**WELWYN HATFIELD BOROUGH COUNCIL  
EXECUTIVE DIRECTOR - PLANNING, PUBLIC PROTECTION AND GOVERNANCE**

**Application No:** 6/2021/1144/VAR  
**Location:** 50 Plough Hill Cuffley Potters Bar EN6 4DS  
**Proposal:** Variation of condition 3 (approved plans) on planning permission 6/2019/2591/HOUSE  
**Officer:** Mr David Elmore

**Recommendation:** Granted

PROPOSED FRONT ELEVATION

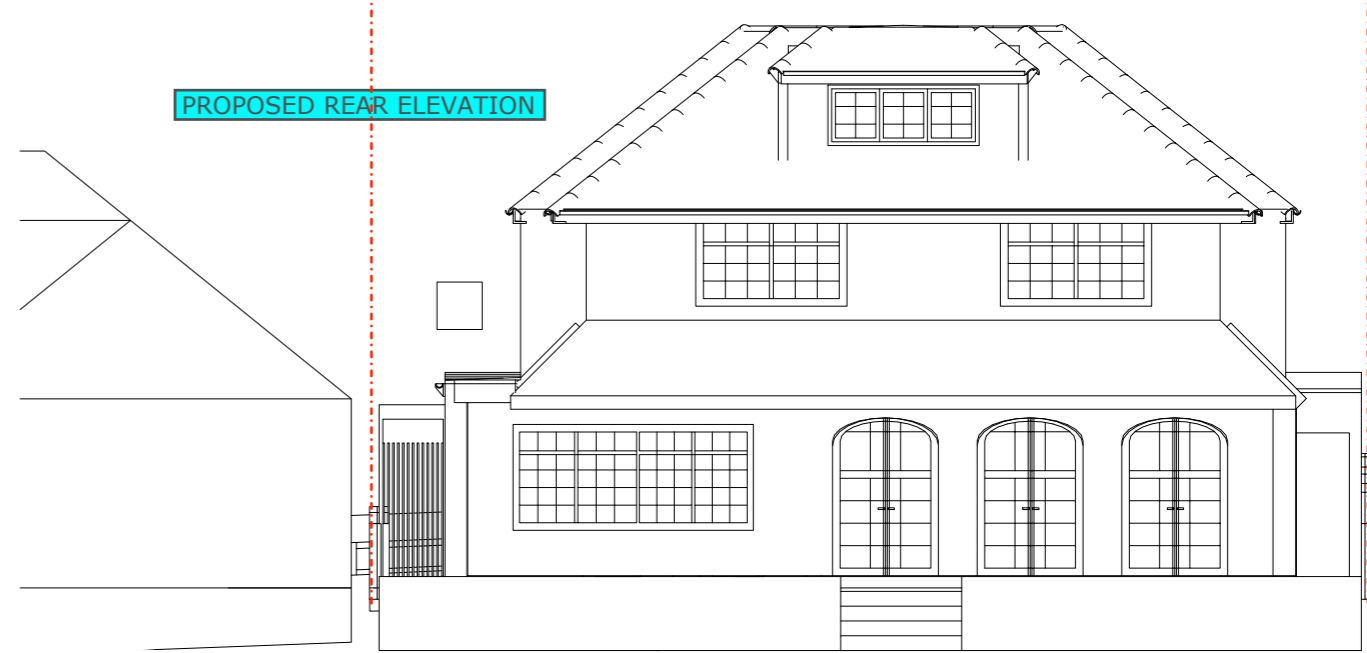
<b>Context</b>	
<b>Site and Application description</b>	<p>This is a Section 73 application for variation of condition 3 (approved plans) of planning permission 6/2019/2591/HOUSE. The variations include:</p> <ul style="list-style-type: none"> <li>- Change of windows on front elevation to central sash with side light panels</li> <li>- Details of external materials. This includes: <ul style="list-style-type: none"> <li>o Roof tile - Marley Concrete Plain Roof Tile Smooth Grey</li> <li>o Front wall - white k render silicone</li> <li>o Windows - White uPVC</li> </ul> </li> </ul>
<b>Constraints (as defined within WHDP 2005)</b>	<p>PAR - PARISH (NORTHAW AND CUFFLEY) - Distance: 0  Wards - Northaw &amp; Cuffley - Distance: 0  A4D - ARTICLE 4 DIRECTION - Distance: 0  HEN - No known habitats present (medium priority for habitat creation) - Distance: 0  SAGB - Sand and Gravel Belt - Distance: 0</p>
<b>Relevant planning history</b>	<p>Application Number: 6/2019/2591/HOUSE  Decision: Granted  Decision Date: 13 January 2020  Proposal: Erection of a ground floor side/rear and first floor extension, including the construction of a rear dormer and installation of rooflights to facilitate the creation of habitable space within the loft and erection of front boundary wall and gates</p> <p>Application Number: 6/2019/1089/HOUSE  Decision: Granted  Decision Date: 04 July 2019  Proposal: Erection of a ground floor rear/side and first floor extension, including the construction of a rear dormer and installation of rooflights to facilitate the creation of habitable space within the loft</p> <p>Application Number: S6/1977/0669/  Decision: Granted  Decision Date: 30 January 1978  Proposal: Single storey side and rear extensions</p>

PROPOSED RIGHT ELEVATION

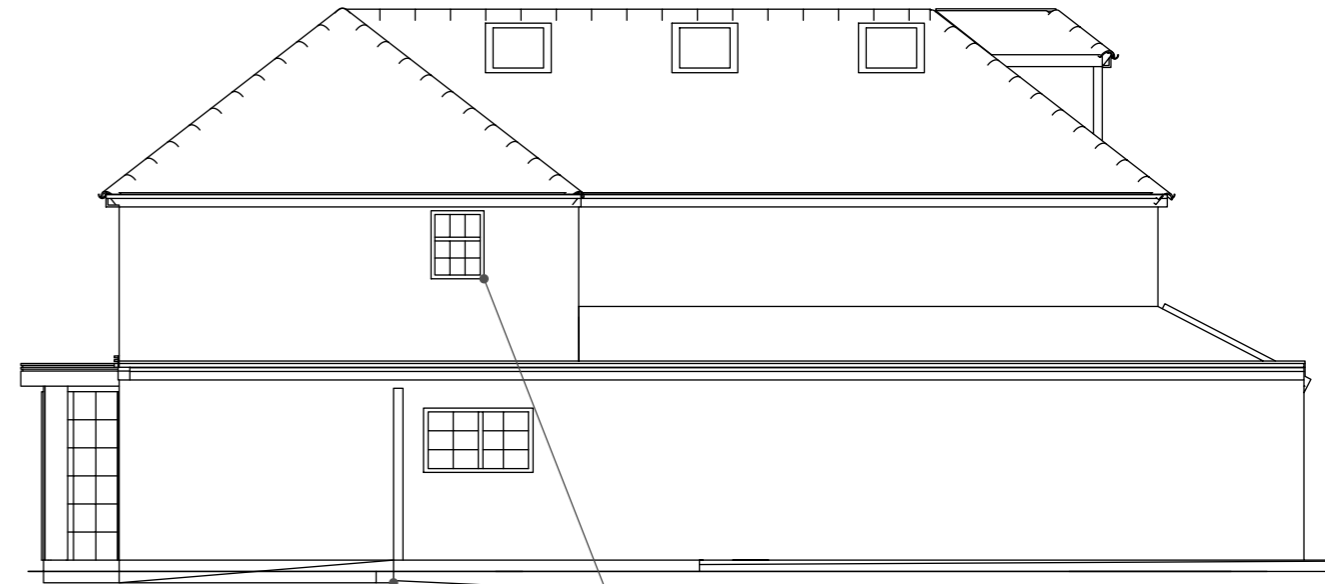
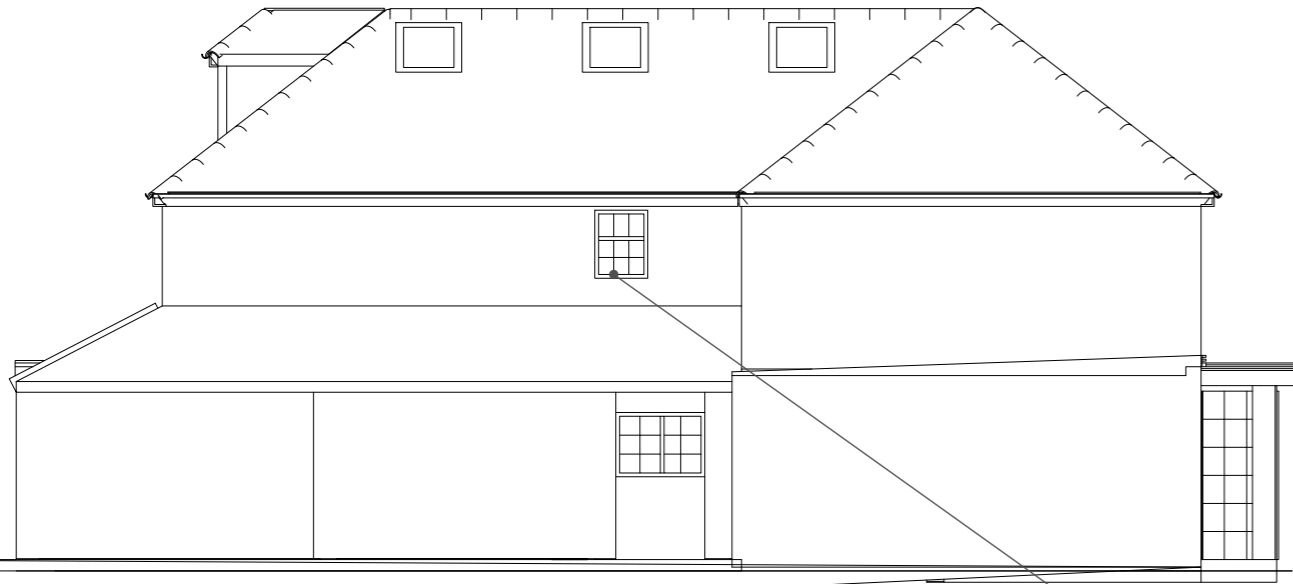
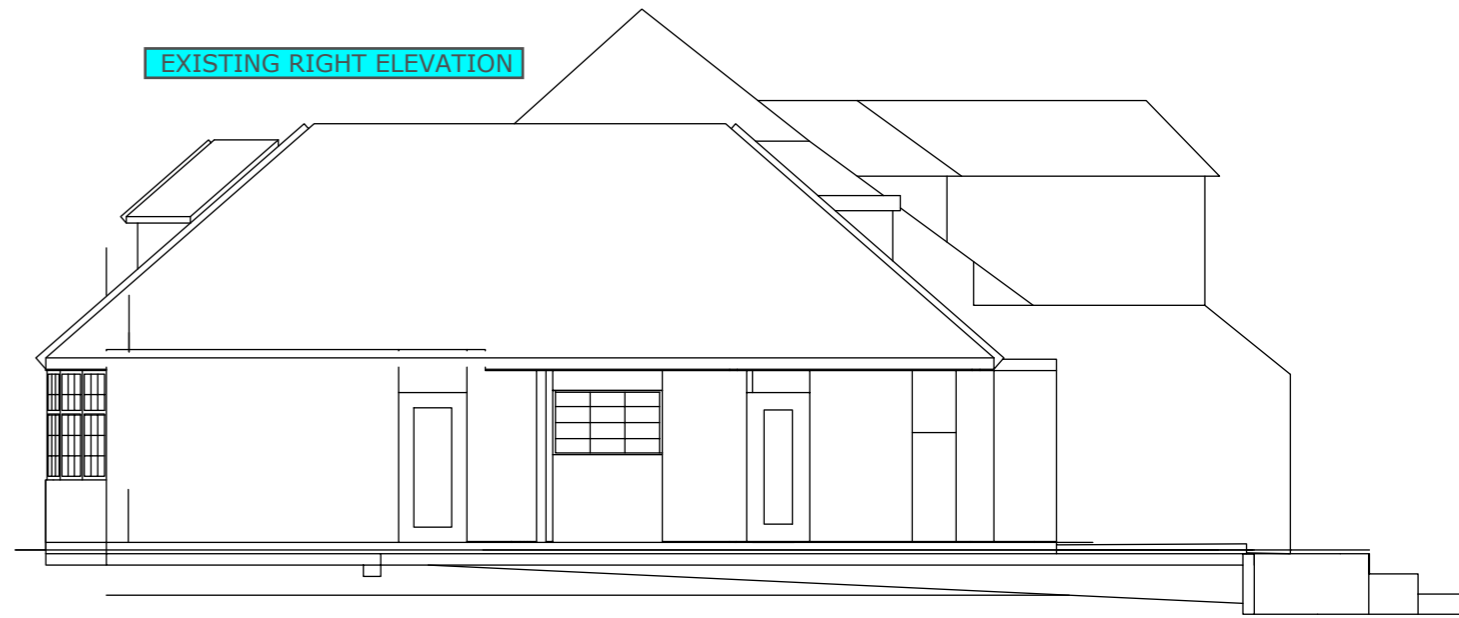
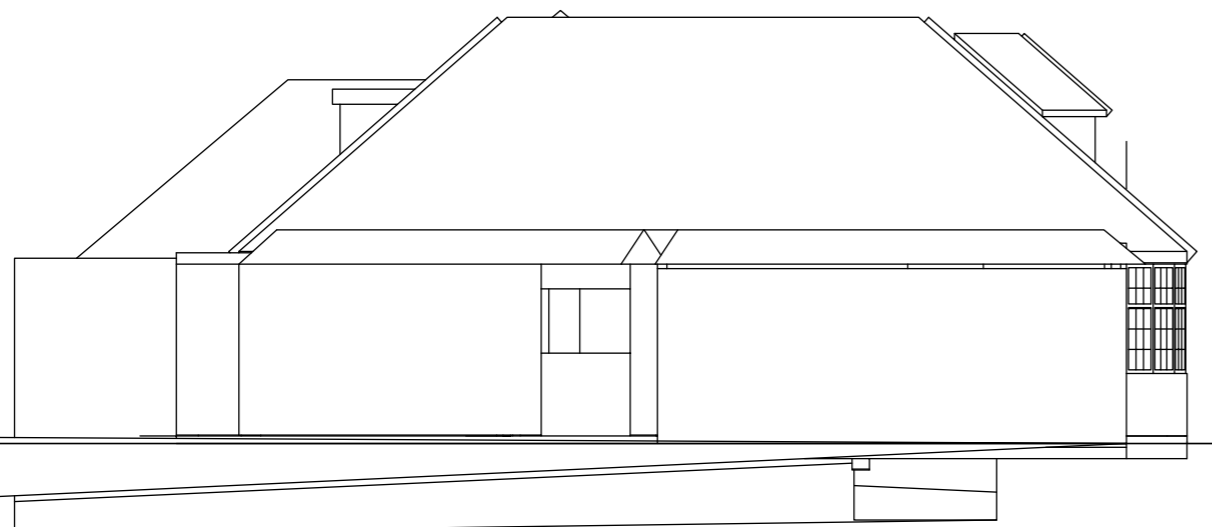
1. Any upper floor window located in a wall or roof slope forming a side elevation of the development hereby approved must be:

- Obscure-glazed; and
- Non-opening (unless the parts of the window which can be opened are more than 1.7 metres above the floor of the room in which the window is installed);

and shall be retained in that form thereafter.
